November 13, 2025

Subject: 1910 Wade Stephenson Road
Holly Springs, NC 27540
Modified Footing Inspection Letter
Harnett County Permit #: SFD2505-0157

S1 FOUNDATION/ROOF
1/4"=1'-0"

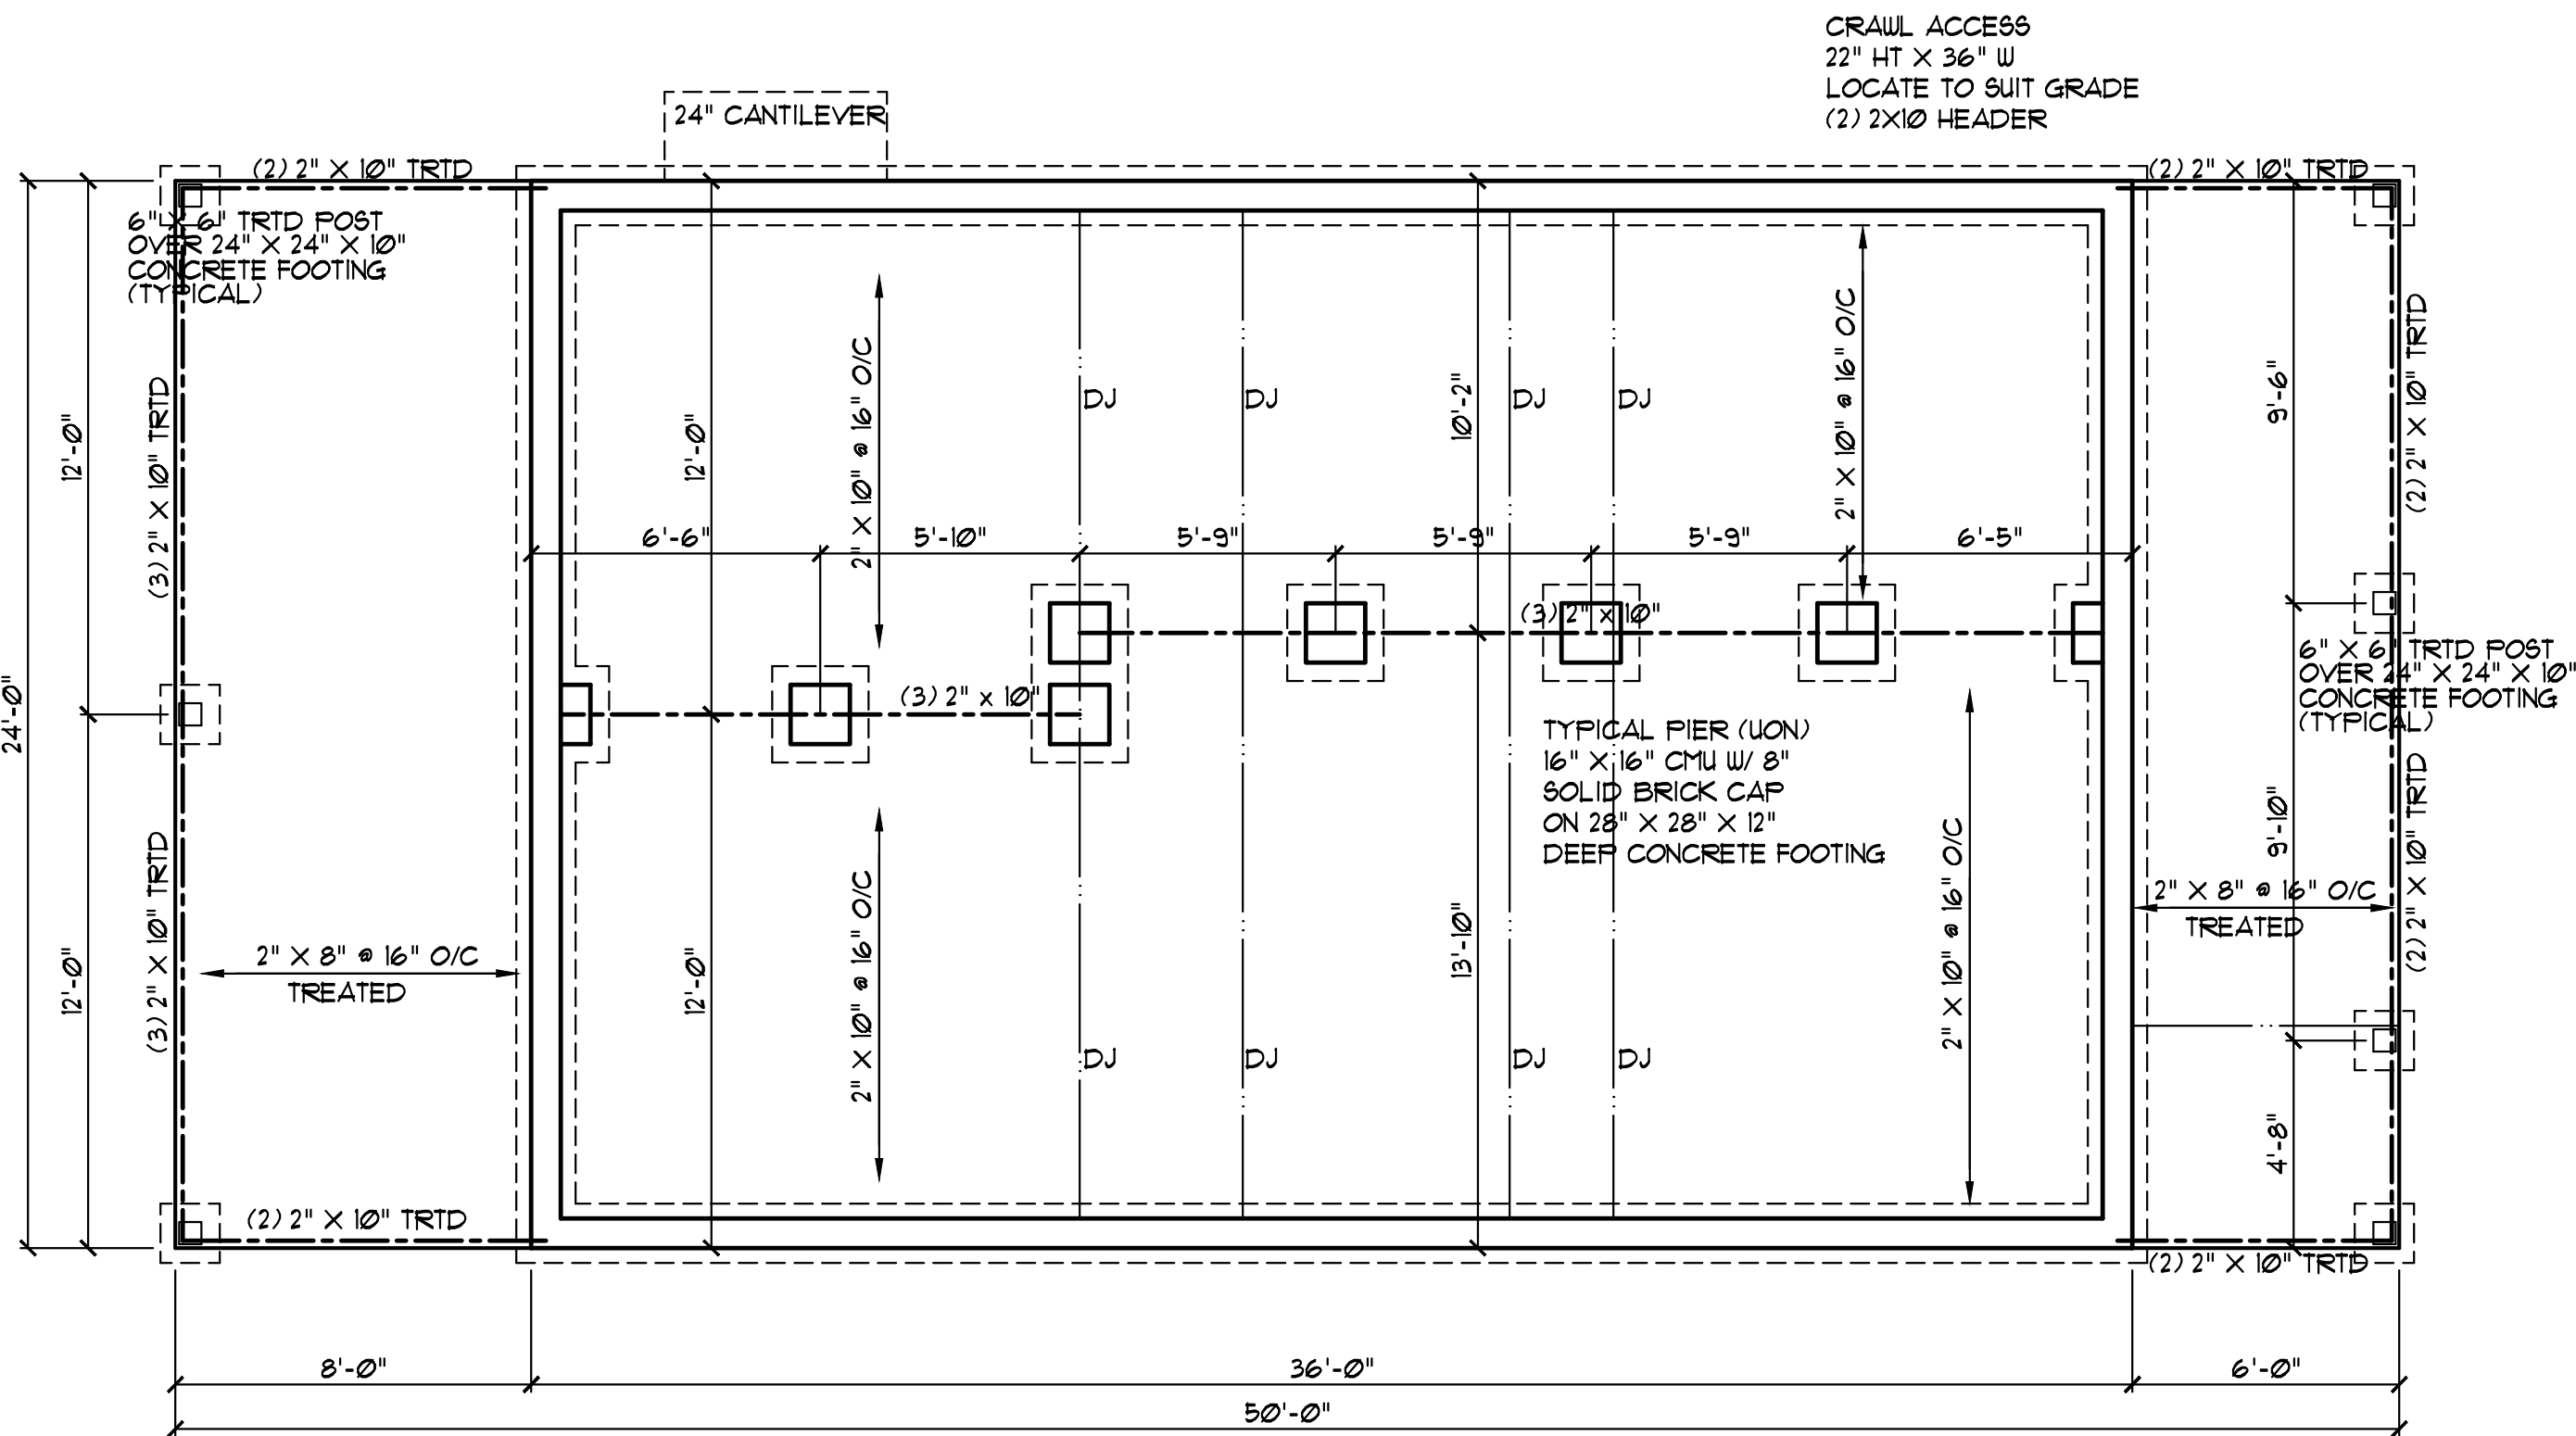
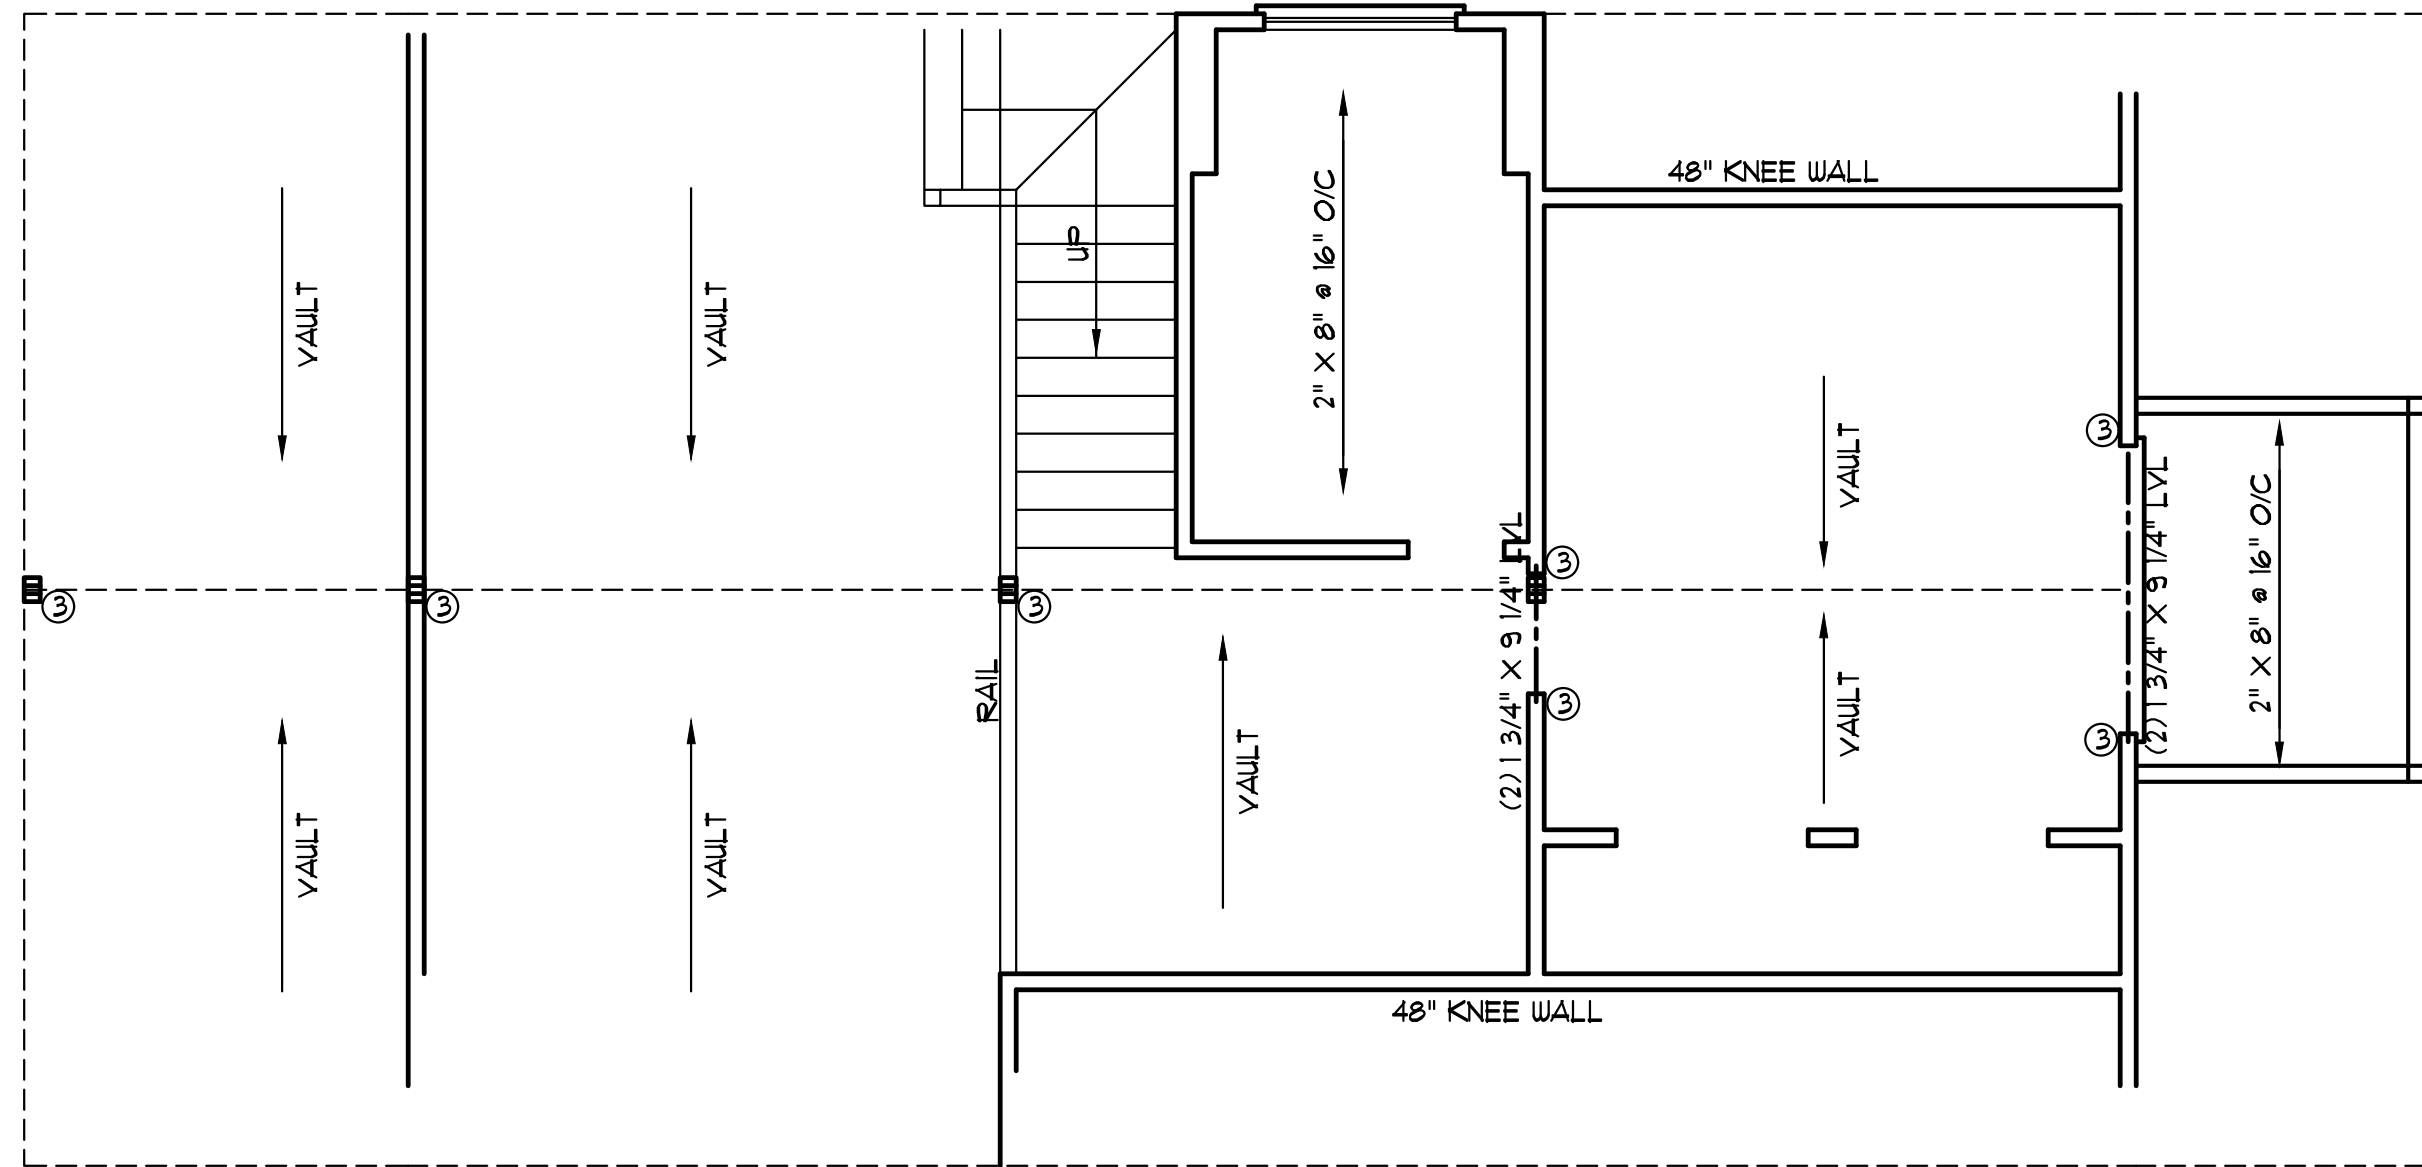
- The footings for the masonry piers at the back portion of the crawlspace were not excavated in the correct location. The footings were excavated too close to the left side foundation wall. The concrete was poured in the excavated footings. The Contractor expanded the newly poured concrete footings to get the CMU piers in the correct location. The Contractor added #4 dowel bars to tie the 2 sets of footings together. The dowel bars are properly installed. The footings are excavated to the proper dimensions, location, and depth. The footings have the proper density (2000 PSF). The Contractor may pour the concrete for the modified footings.
